2 November 2020

Your ref: H20-0936-20

***RE: PROPOSED DWELLING ADJ 28 JARVIS GATE, SUTTON ST JAMES  
FOR MR D SULLIVAN***

SITE PLAN

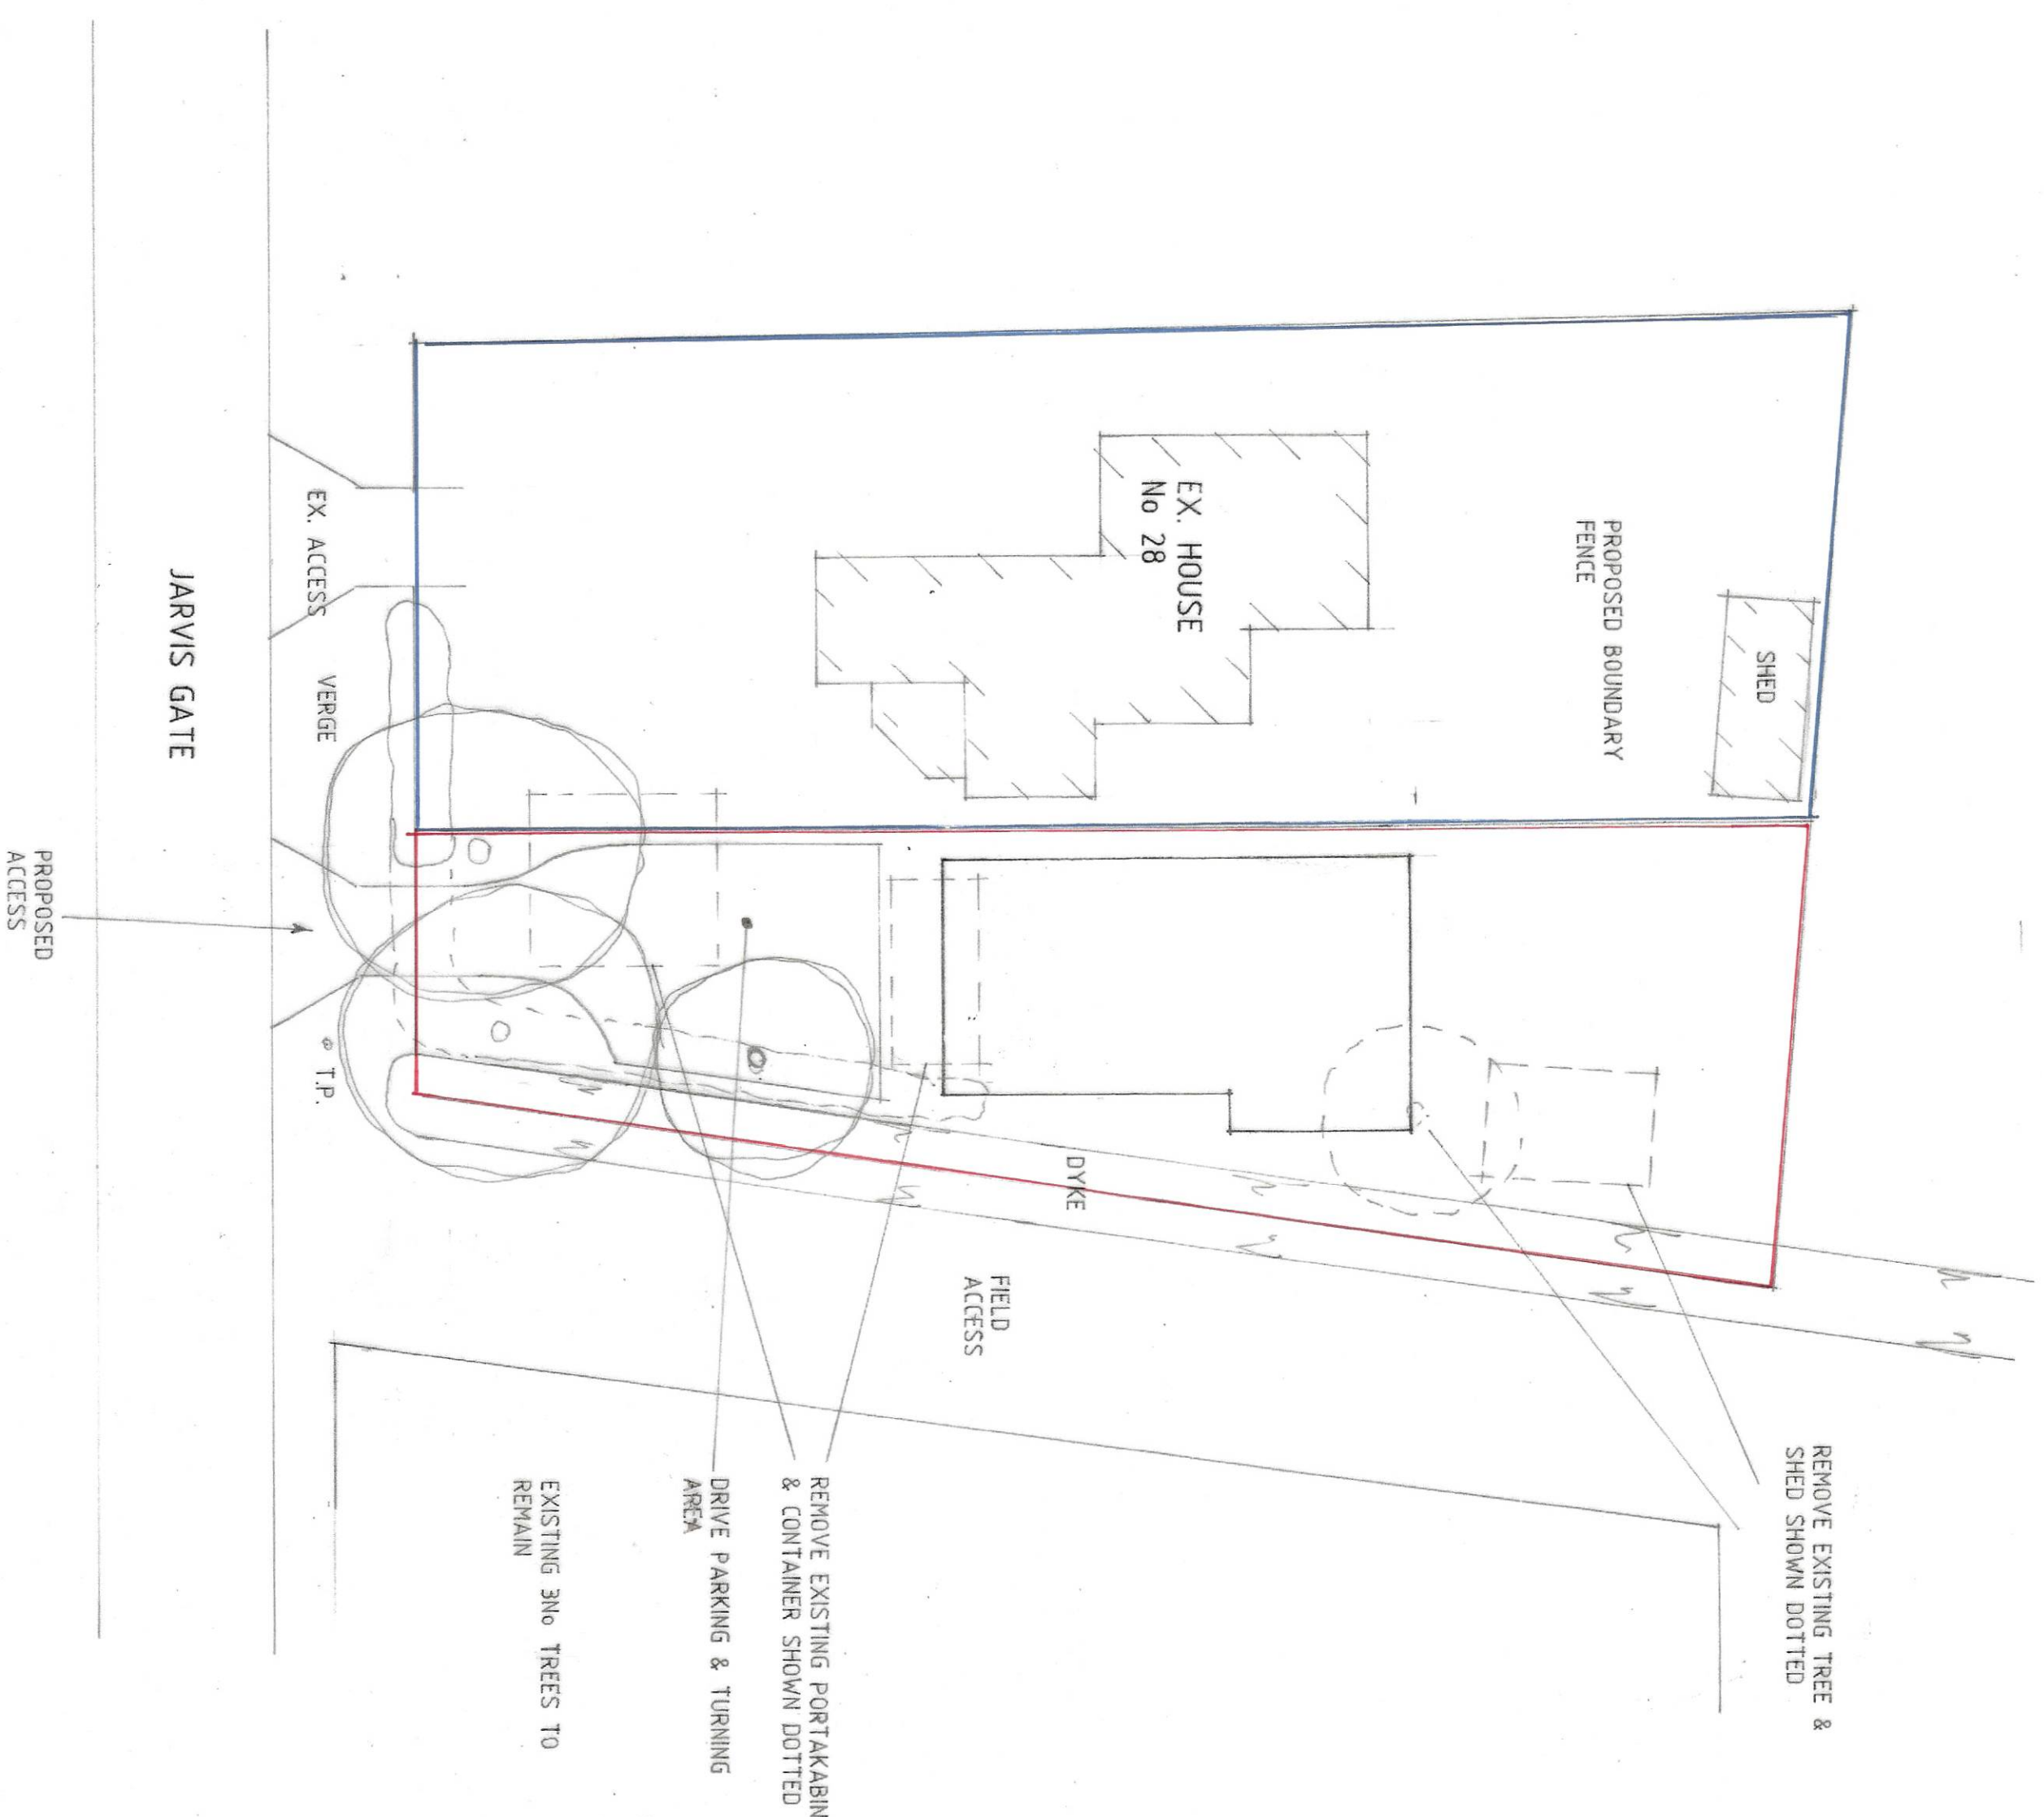
Further to your email and the Lincolnshire County Council attachment, I have checked with my client and the boundary is, in fact, on the inside of the dyke – see attached Land Registry Plan.

I therefore attach a revised coloured Site Plan and OS map. As regards the relationship with the proposed bungalow and the dyke it is intended for the foundations close to the dyke to be taken down to below the invert of the dyke.
